**Subject: Ivilo Minor Subdivision (MS228)**

The Community Services Department has reviewed the Ivilo Minor Subdivision application and is providing the following comments on behalf of El Paso County Parks.

This is a request by SMH Consultants on behalf of Pawl Posorski. The applicant is requesting approval for a minor subdivision and rezone for Ivilo Minor Subdivision. The property is located at 6385 Vessey Road approximately four miles north of Colorado Springs. The subject property is 14 acres and is currently zoned RR-5. A concurrent application to rezone the property from RR-5 to RR-2.5 is also being considered. The proposed minor subdivision would consist of three single family residential lots of the following sizes: Lot 1: 5.4 acres, Lot 2: 4.1 acres, and Lot 3: 4.6 acres. Access to the proposed subdivision will be via a new shared driveway off of Vessey Road which will provide access to all three lots.

Final Plat IVILO SUBDIVISION

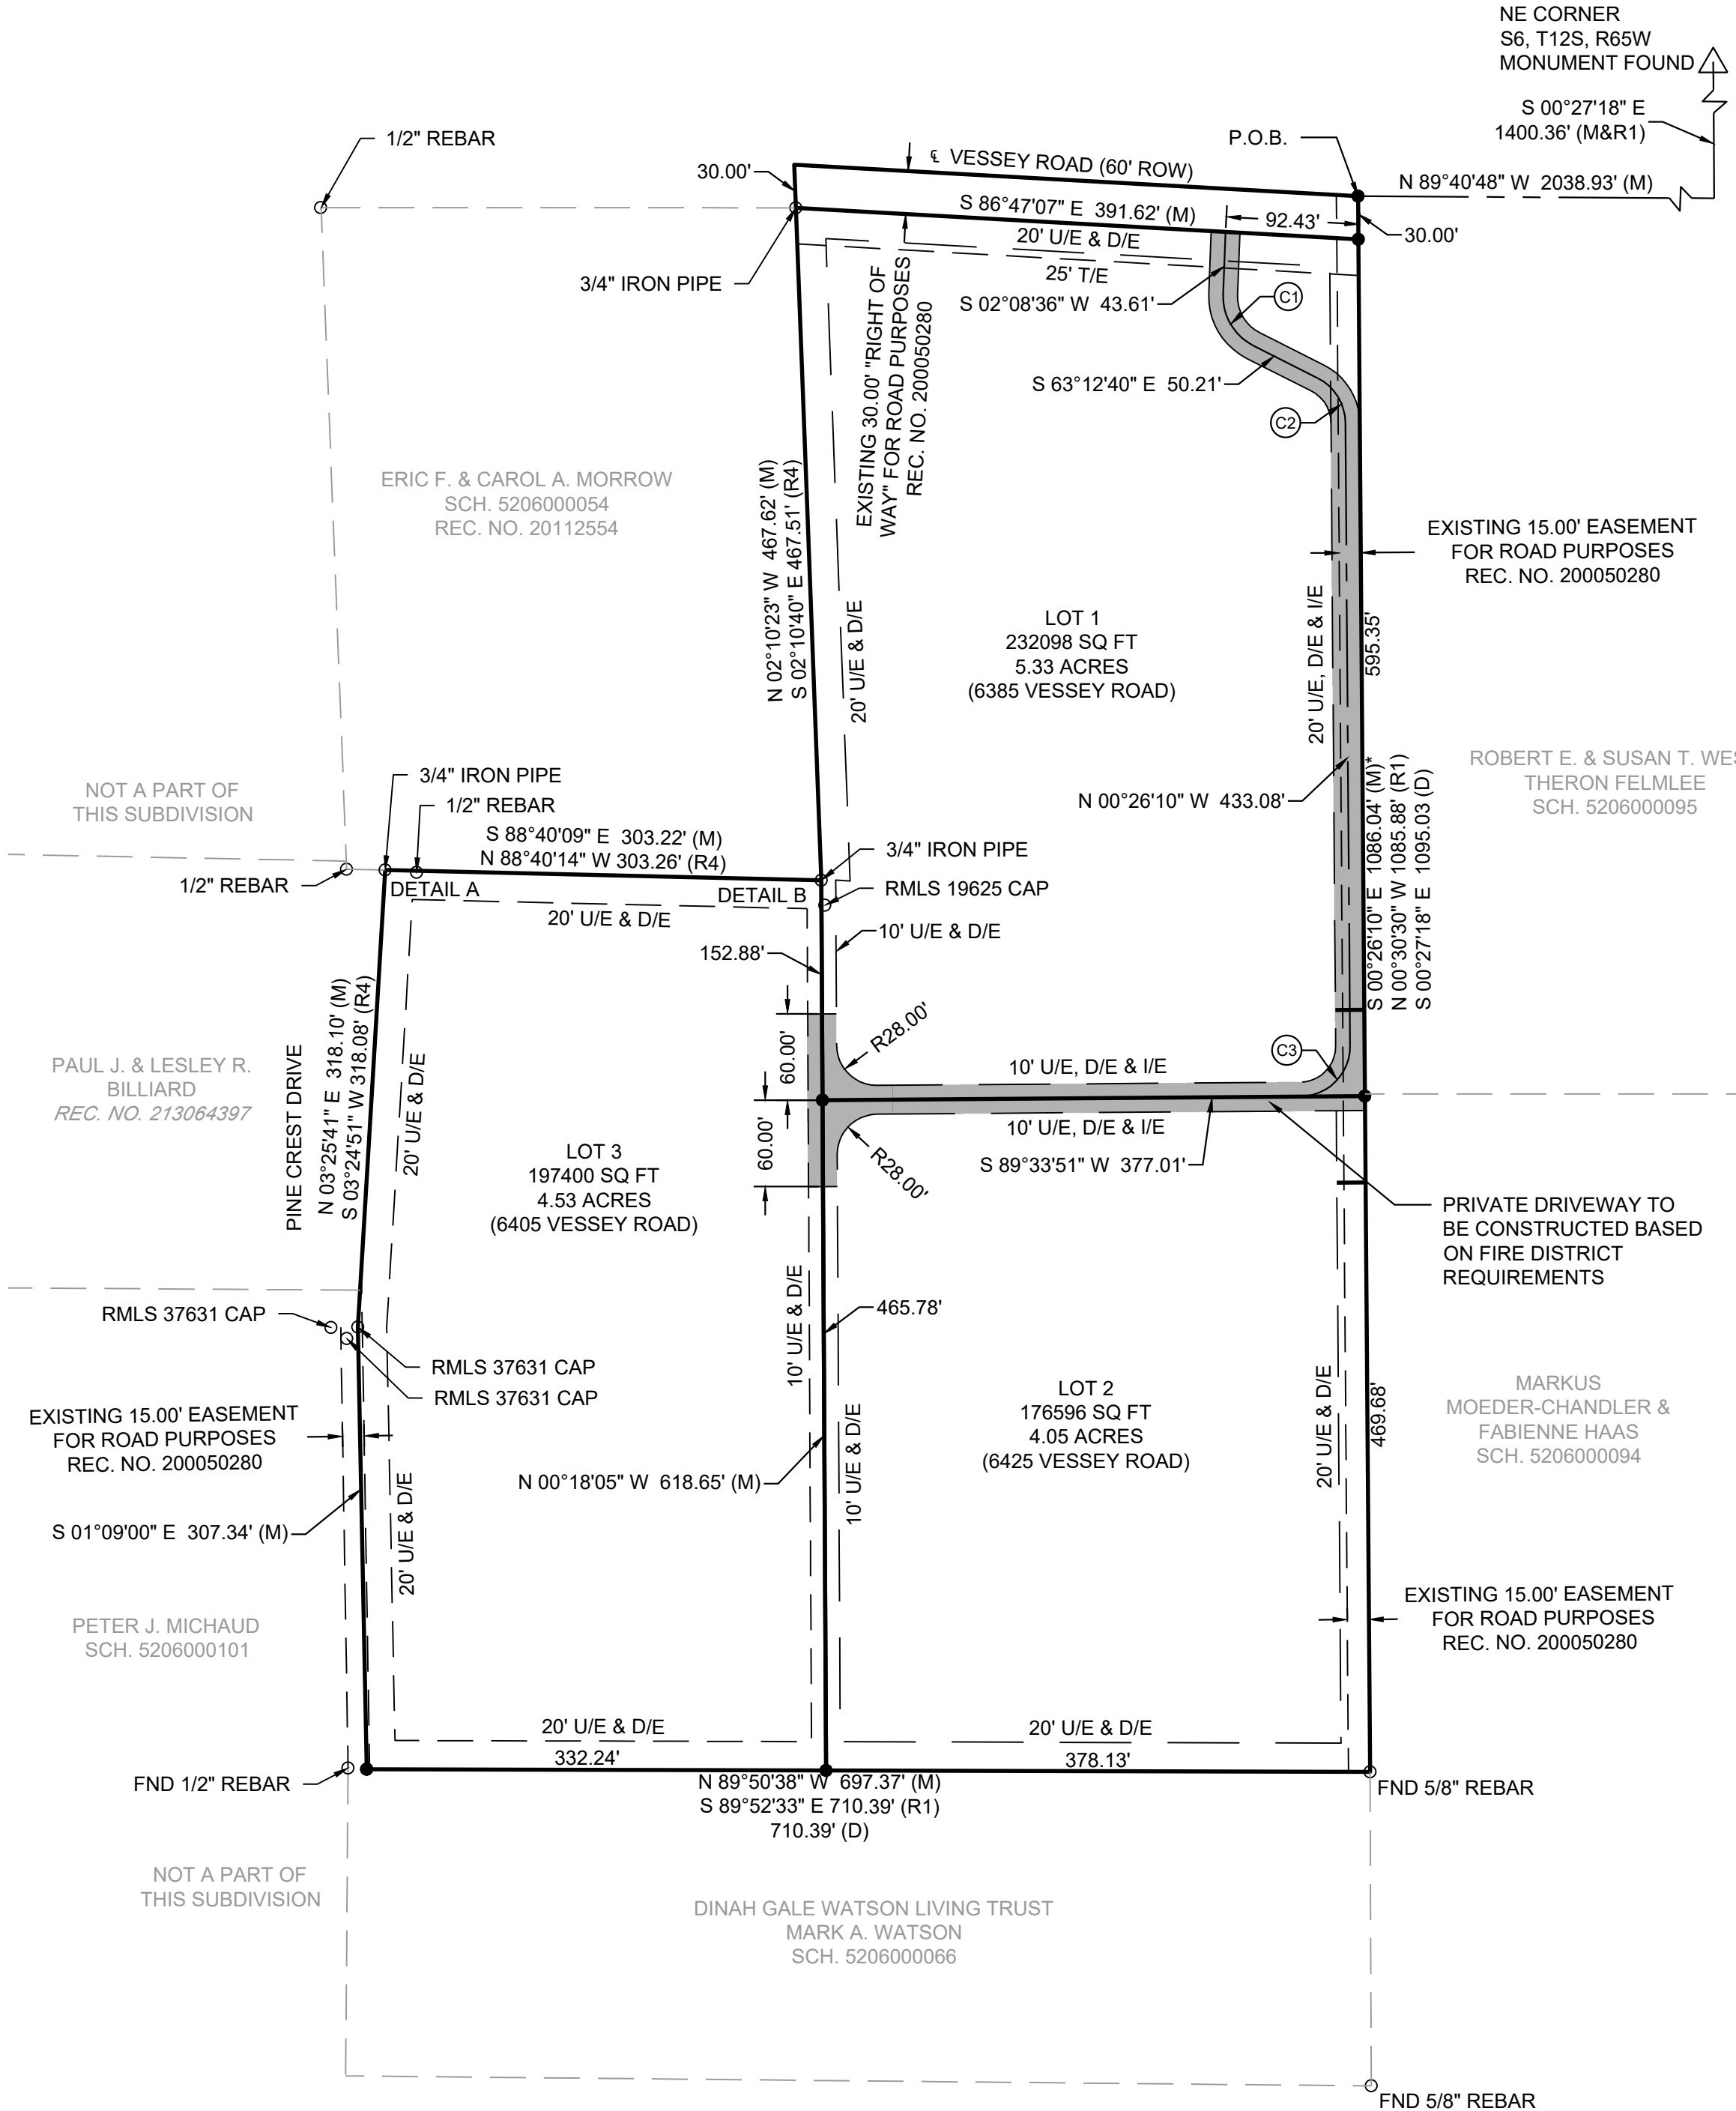
County Parks requests trail easements where development projects impact proposed County trails. As it pertains to this application, the County requests that the landowner provide a 25-foot-wide public trail easement along the north side of the minor subdivision, adjacent to the dedicated right-of-way for Vessey Road, that will allow for the construction and maintenance by El Paso County of the Palmer Divide Regional Trail.

*The Park Advisory Board recommends that the Planning Commission and the Board of County Commissioners include the following conditions when considering and/or approving the Ivilo Minor Subdivision and Rezone: (1) designate and provide to El Paso County a 25-foot-wide public trail easement along the south side of the dedicated right-of-way for Vessey Road that allows for the construction and maintenance by El Paso County of*

*the Palmer Divide Regional Trail, and dedicate the easement to El Paso County prior to the recording of the Final Plat (2) require fees in lieu of land dedication for regional park purposes in the amount of \$1,380.*
